MetroLink Dublin
Swords to City Centre
Module 1 Presentation

23060-X-XX-RP-TMT-T-0006

Site Address:
O' Scanall Veterinary Surgeons,
Miltown Fields,
Swords, Co Dublin

1 Executive Summary

Project	Drawing Title	Drawing Status
Estuary - Seatown Landscape Layout Preliminary Design Issue		S4
Drawing N°	ML1-JAI-ARL-SC01_XX-DR-Y-00001	
Scales Original Size A1	1:1000	Sheet 1 of 3

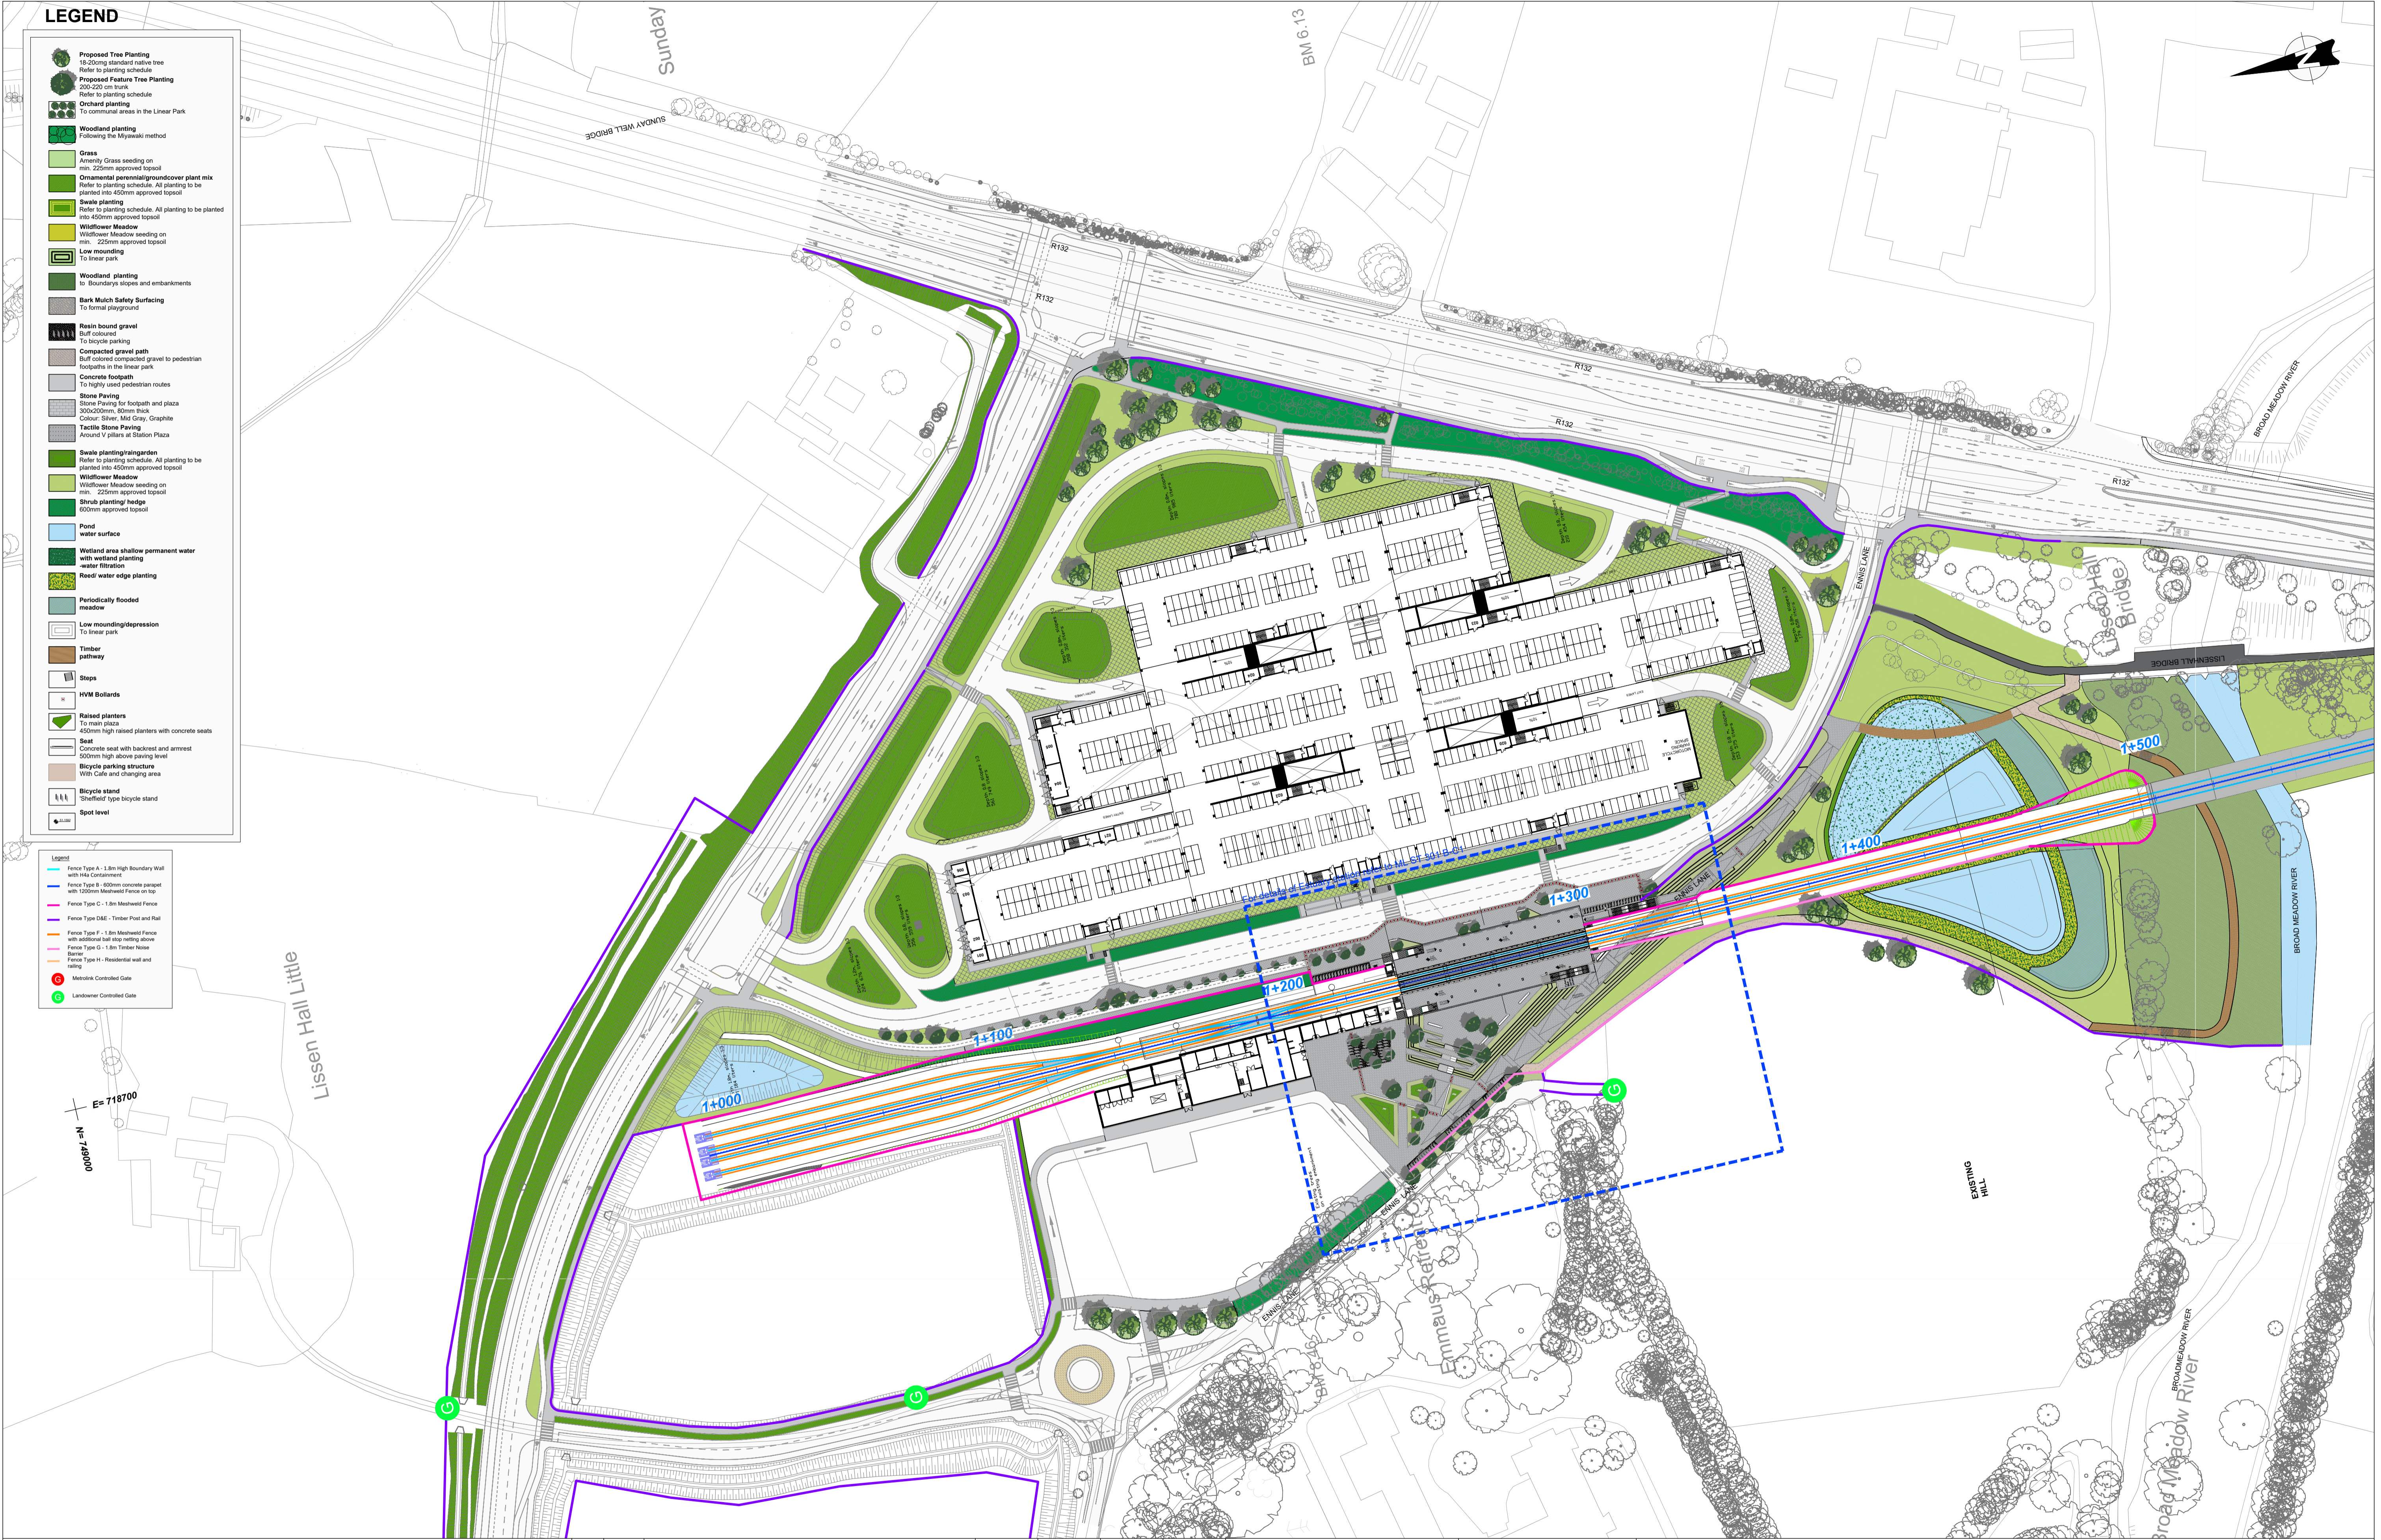
Fig 3.4 is extracted from the railway order plans/ drawings - Landscape drawings. It provides a guide on how the metro link will be coordinated with Bus Connects. The extracts to the right illustrate this more clearly. Fig 3.5 shows the metro-link interpretation of the Bus Connects junction, while Fig 3.6 shows the Bus Connects railway order drawings. We note significant discrepancies in these and seek clarity as to the extent to which these are coordinated, with particular focus on dust, noise, and vibration.

Can the applicant advise if the proposal has been coordinated with Bus Connects, with particular emphasis on impacts from dust, noise, and vibration, and provide evidence of this coordination?
